Subject: FW: FG/171/18/DOC - Peugeot Garage Premises, Littlehampton Road,

Environmental Health: Agree to discharge of Condition on the basis of the attached Construction Management Plan (HNW Architects Job No 17036, Revision B, 07.12.2018).

Environmental Health: Application for discharge of conditions. Further information required.

DRAWING TITLE
Proposed external lighting scheme

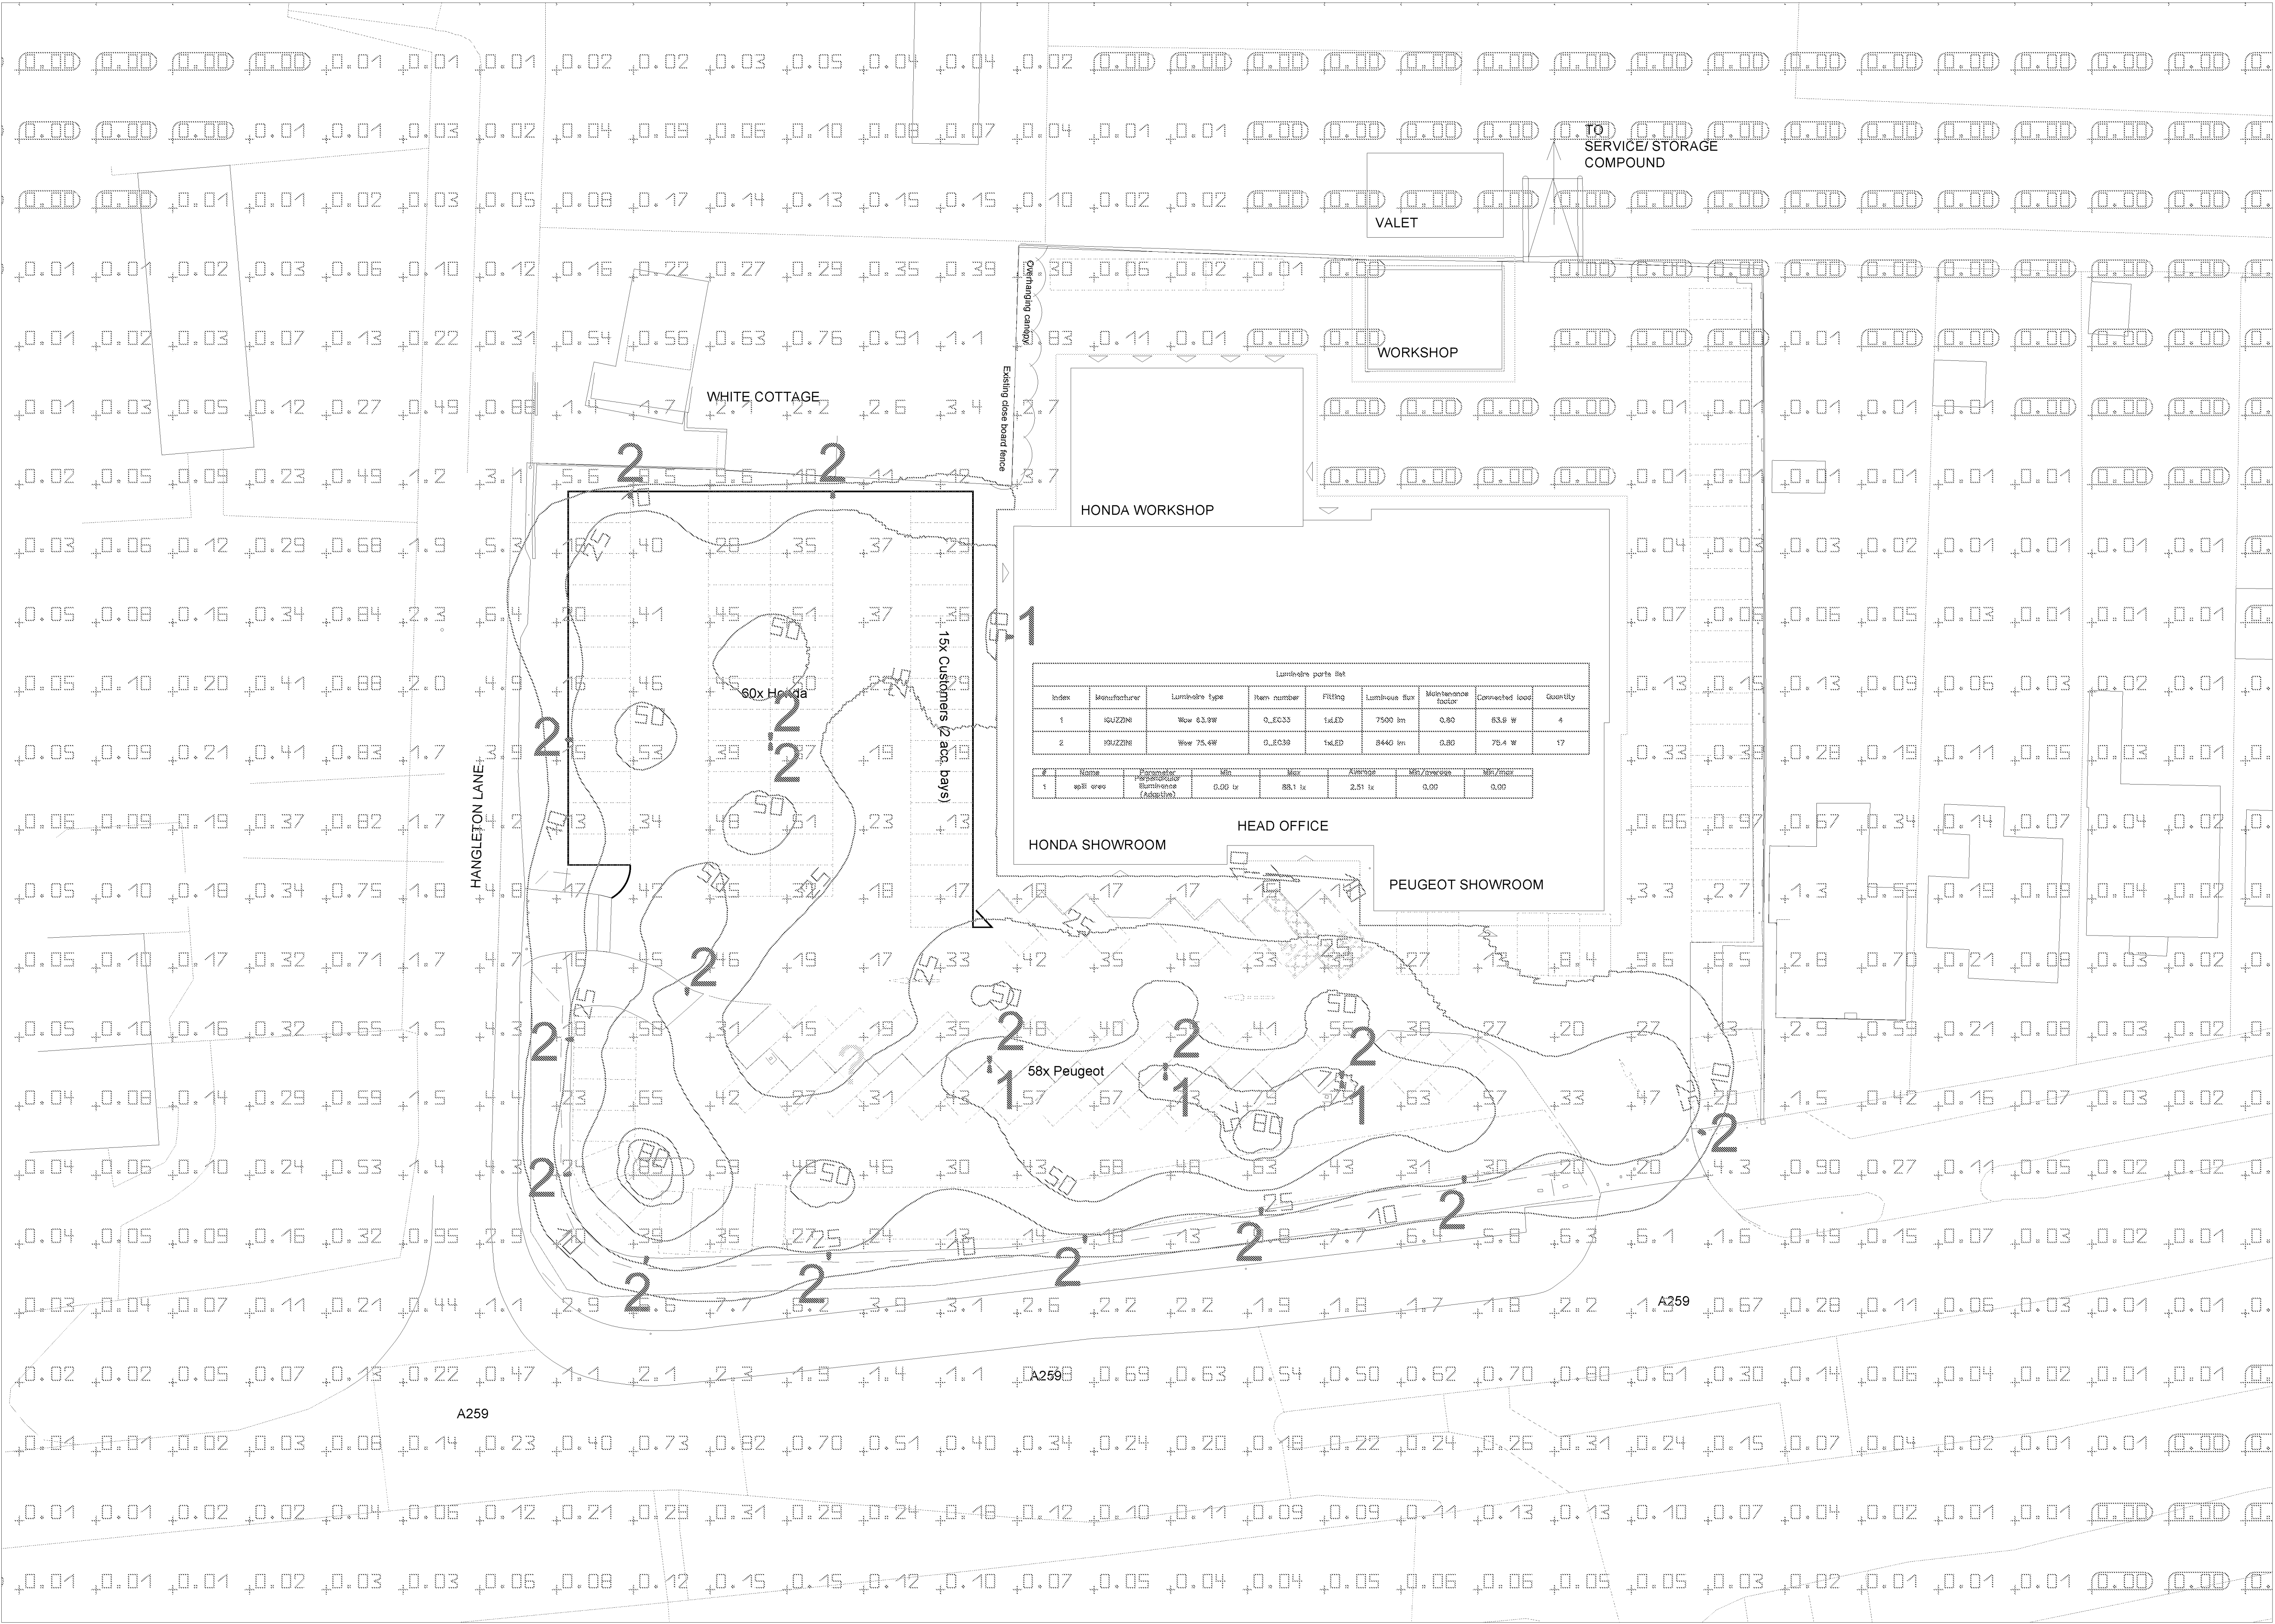
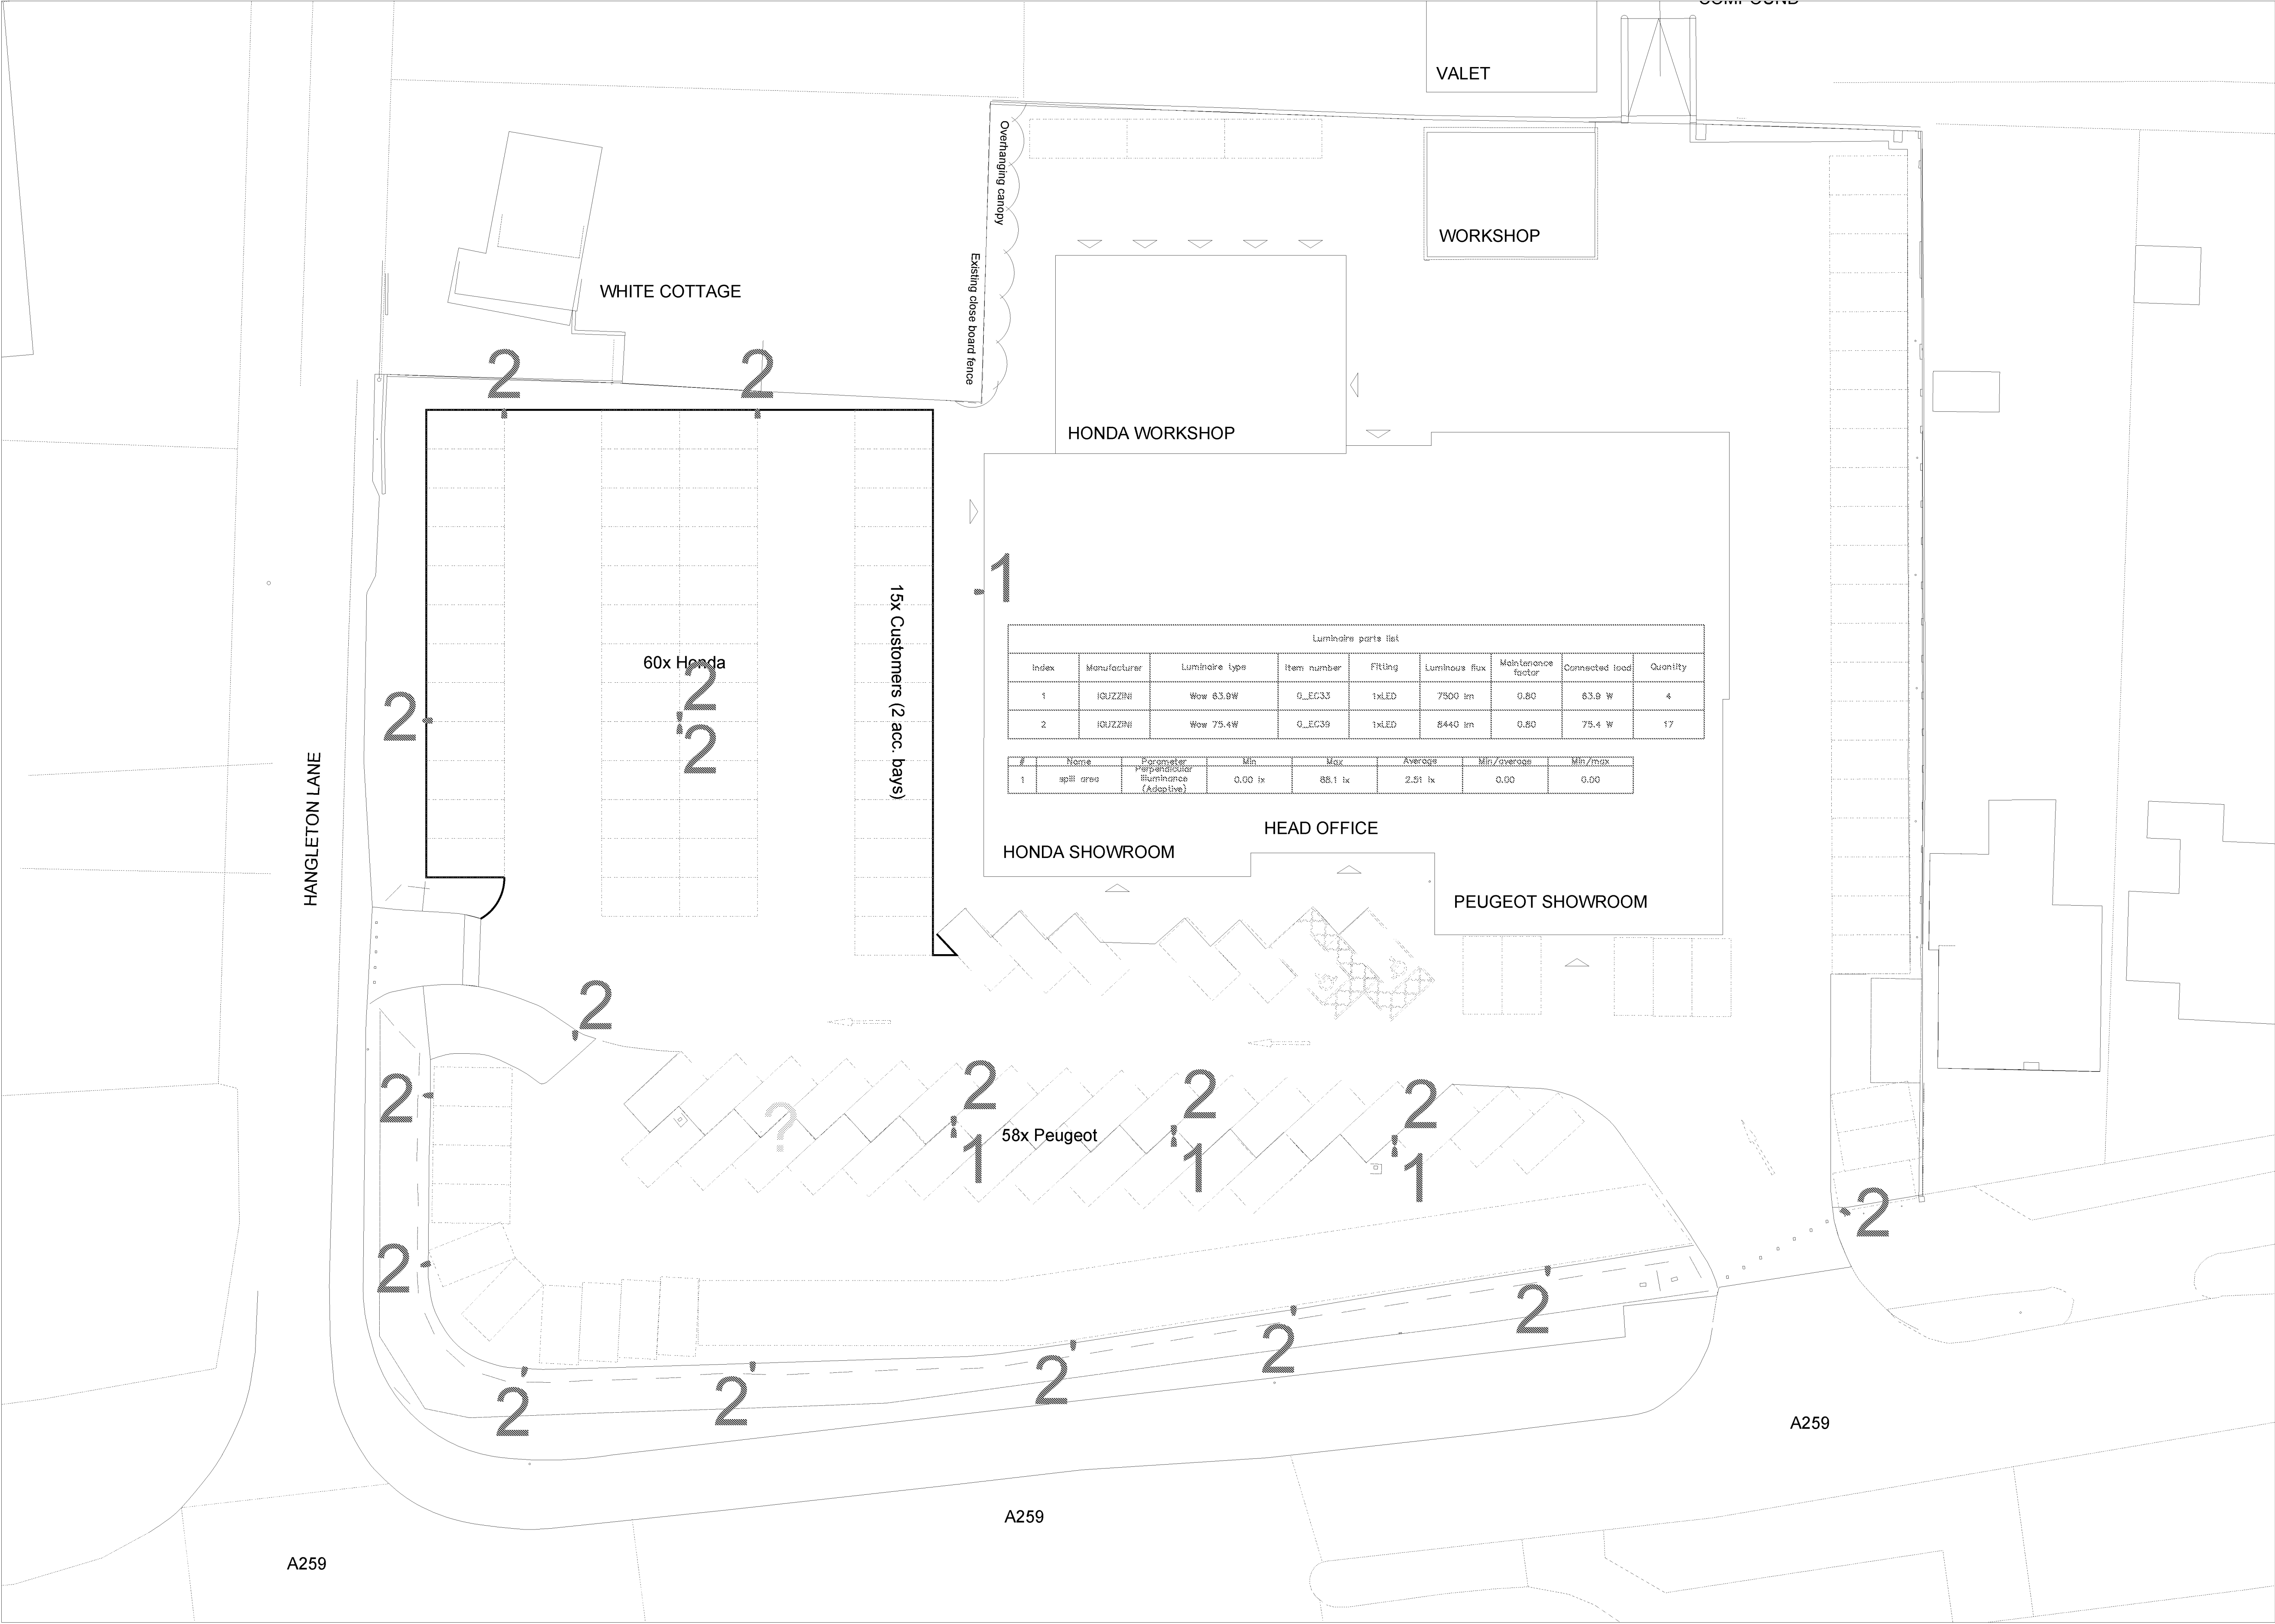
Lighting Plan: Lower level lighting, specified as 'Type 1' to be provided to areas proximal to sensitive receptors and

to the north of the site in order to prevent detriment to the amenity of these properties and South Downs National Park.

I understand that our electrical engineer will contact the EH officer on her return from leave on Monday to discuss the external lighting design comments further. Hopefully to a resolution asap.
